**New High School in Jerrabomberra (SSD-24461956)
Response to Submissions**

ATTACHMENT 1 – KEY ISSUES

ACCESSIBILITY VIA DAVID MADEW OVAL

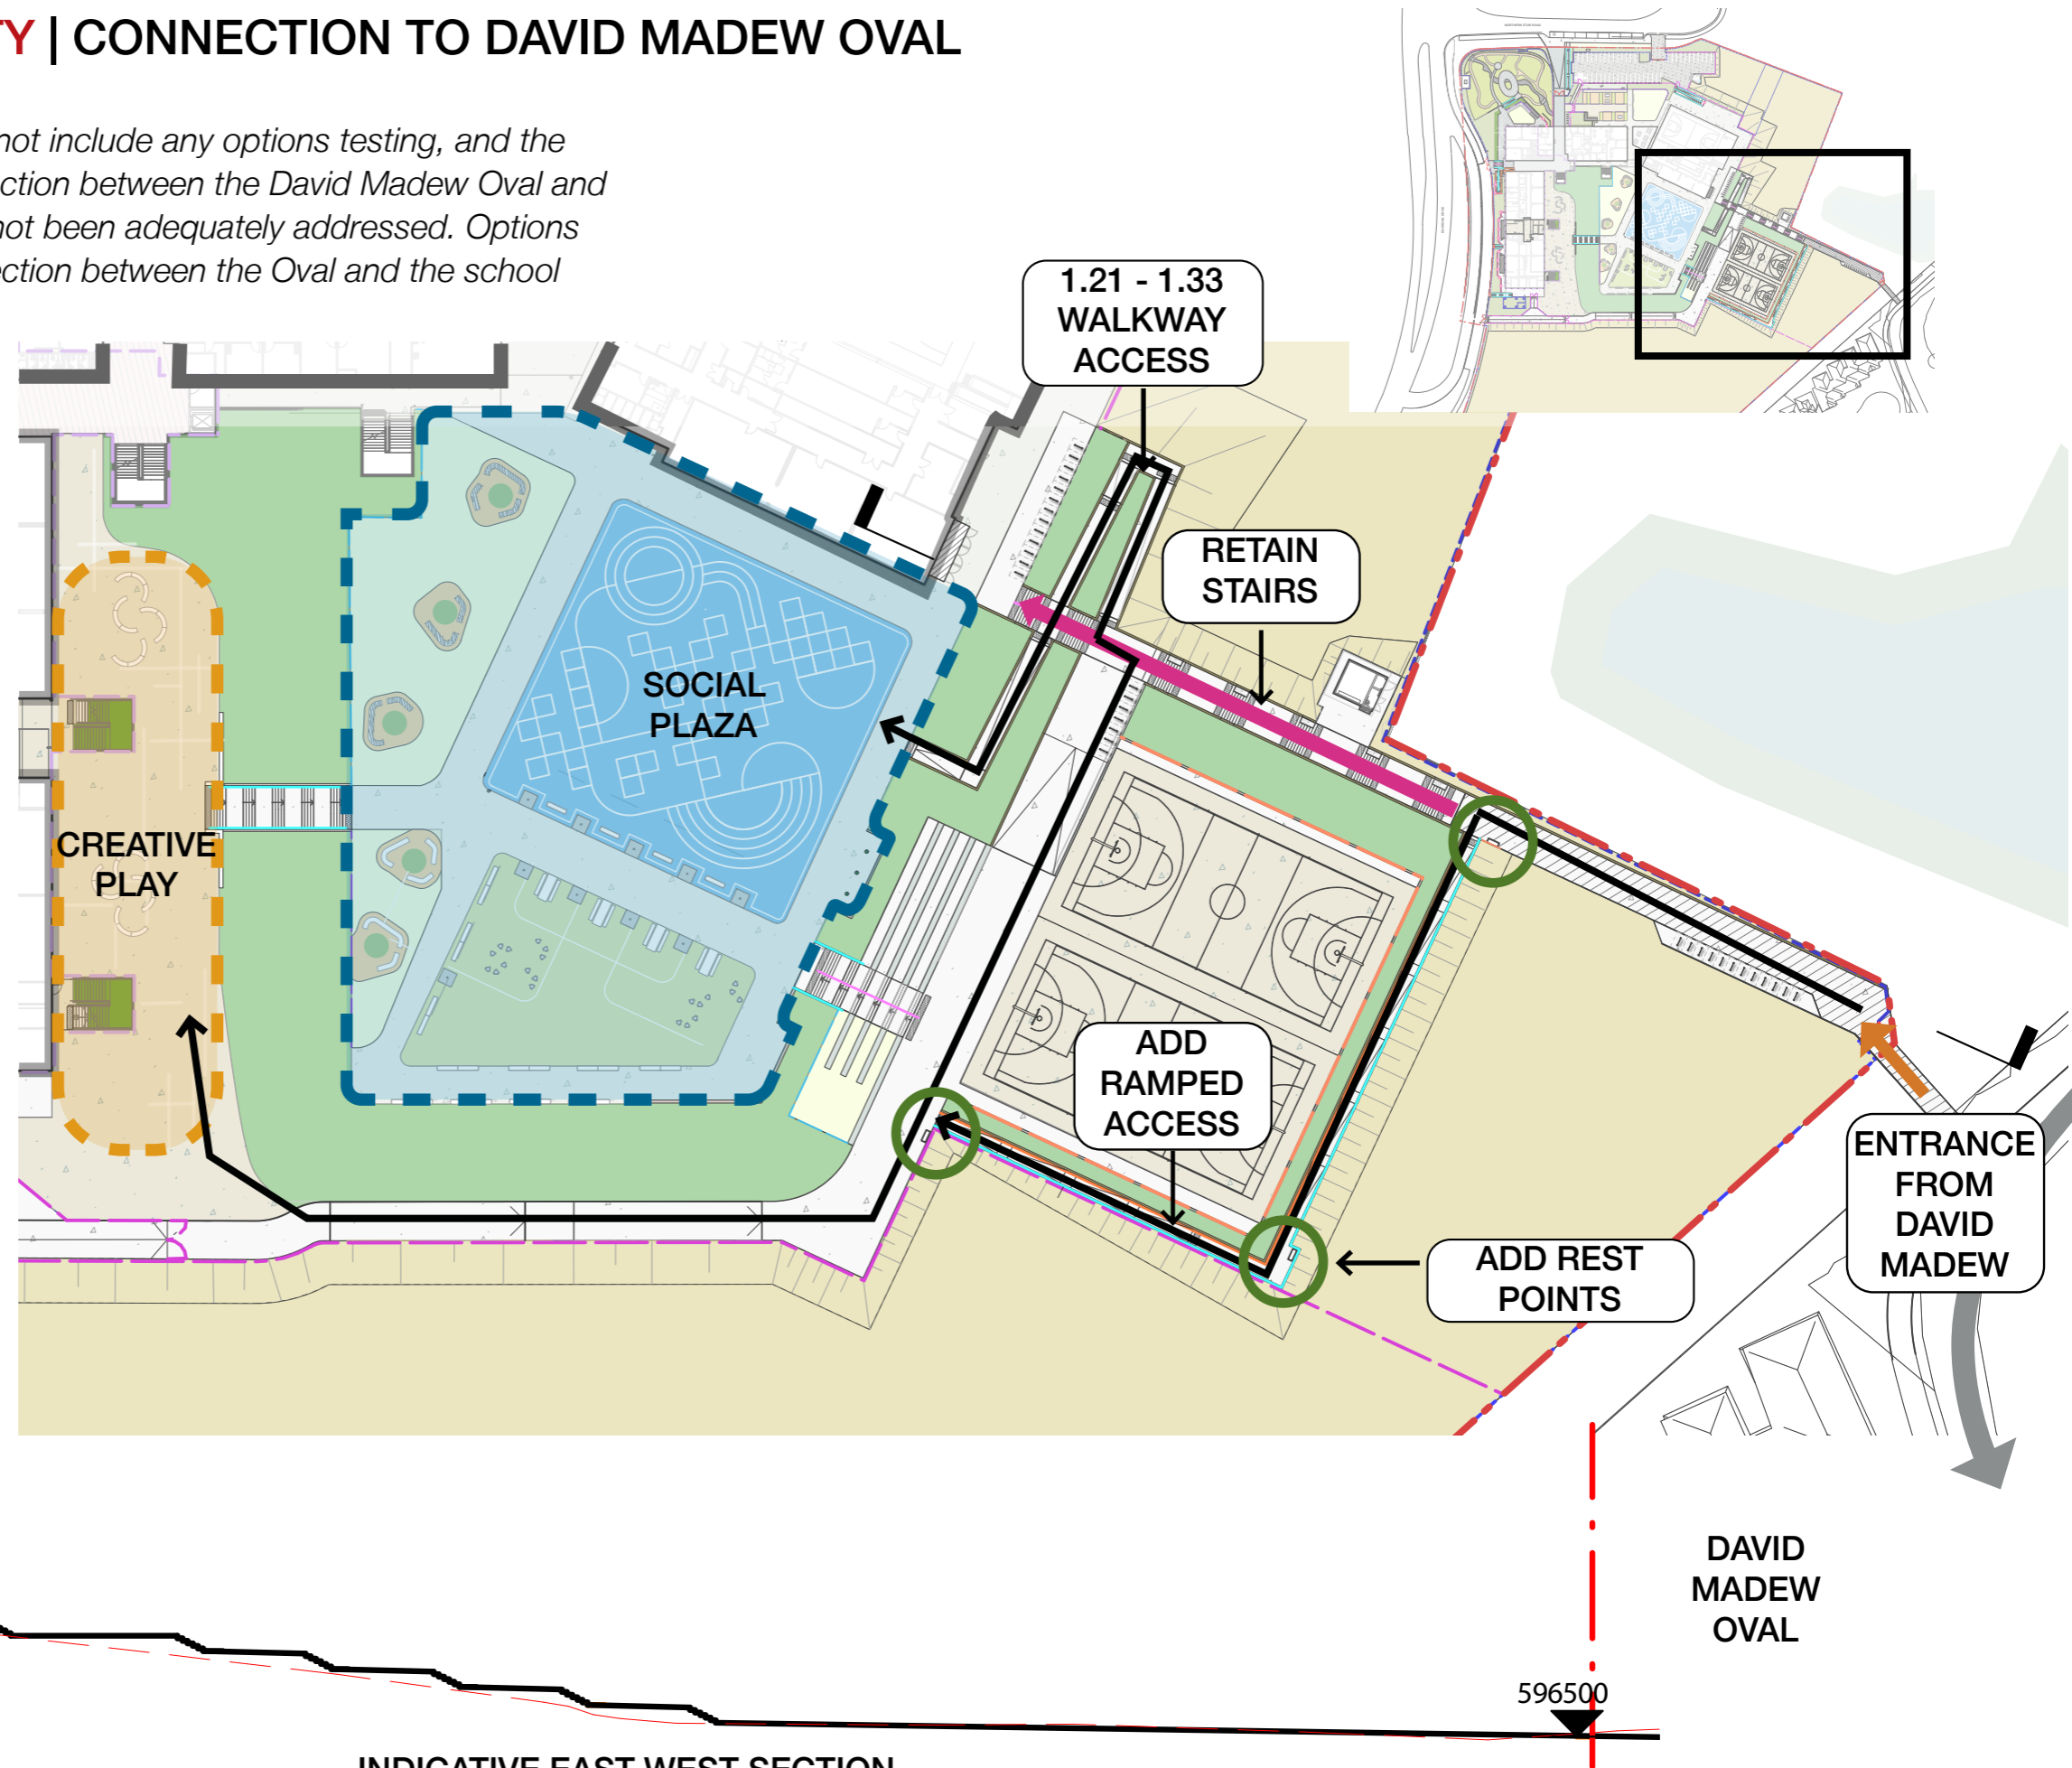
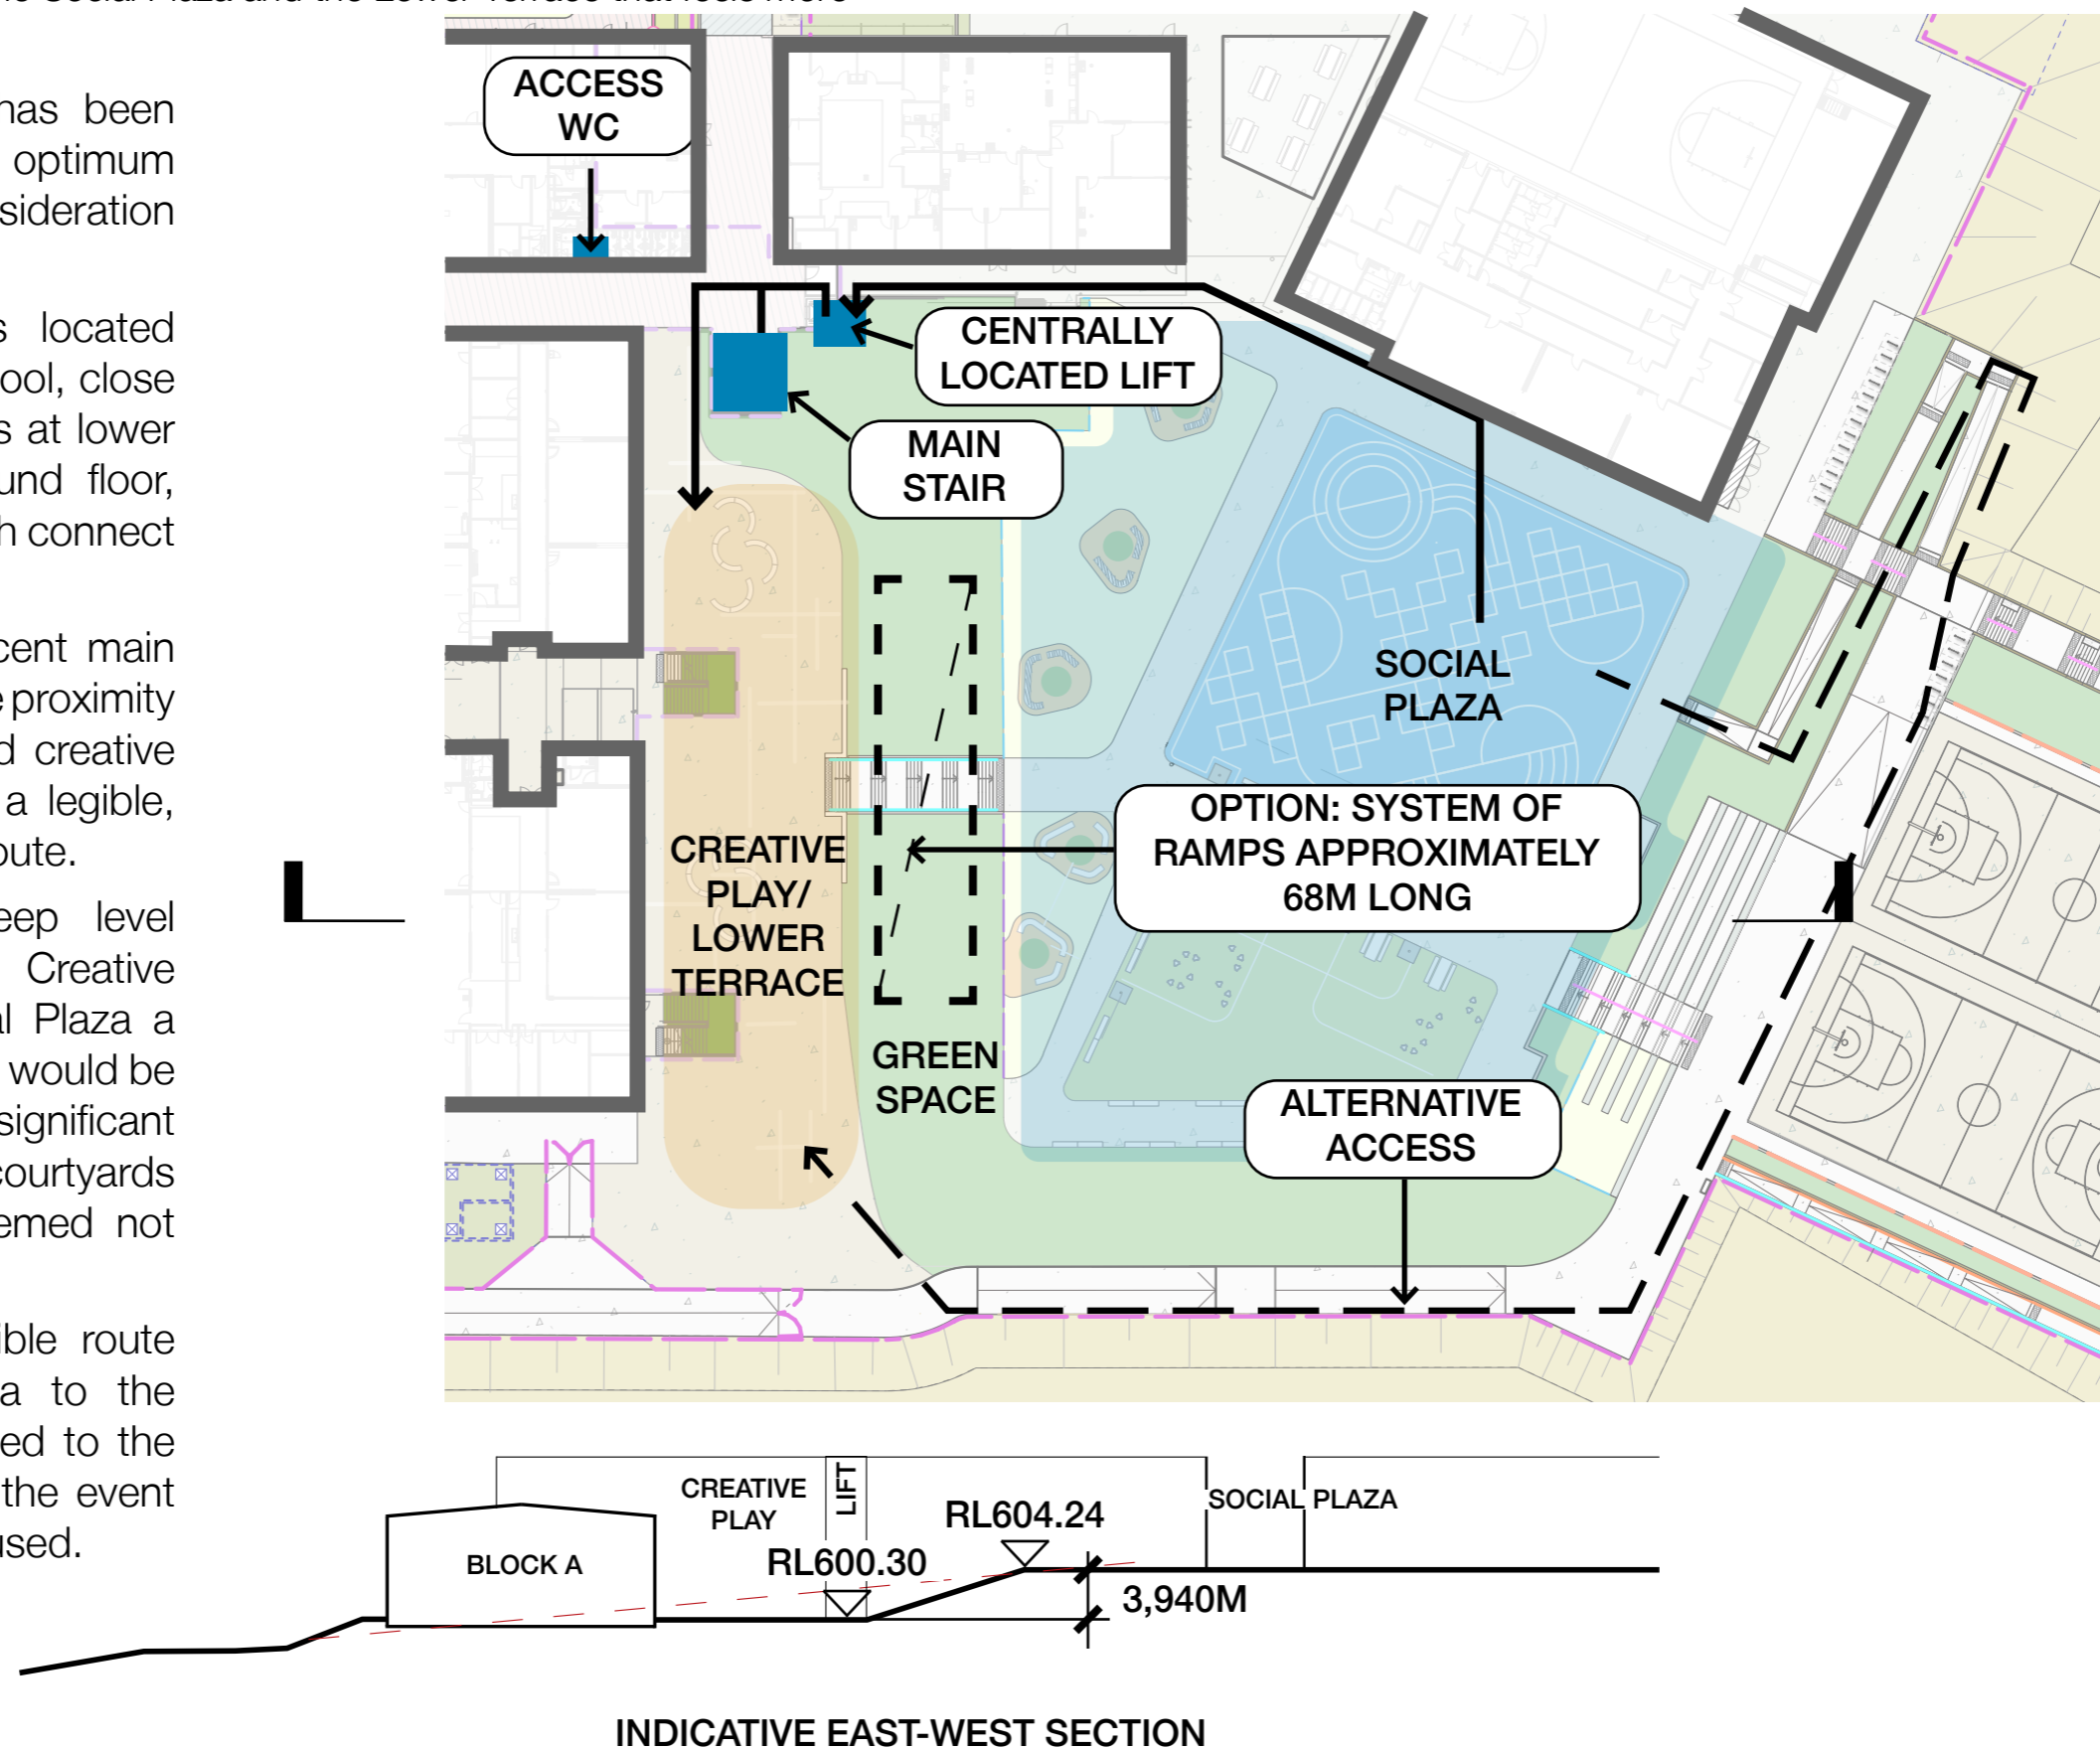
- The following recommendations of the SDRP advice must be addressed:
 - *Recommendation 7c* – the response does not include any options testing, and the recommendation to explore how the connection between the David Madew Oval and the school is connected and inclusive has not been adequately addressed. Options to provide an inclusive and equitable connection between the Oval and the school must be explored.
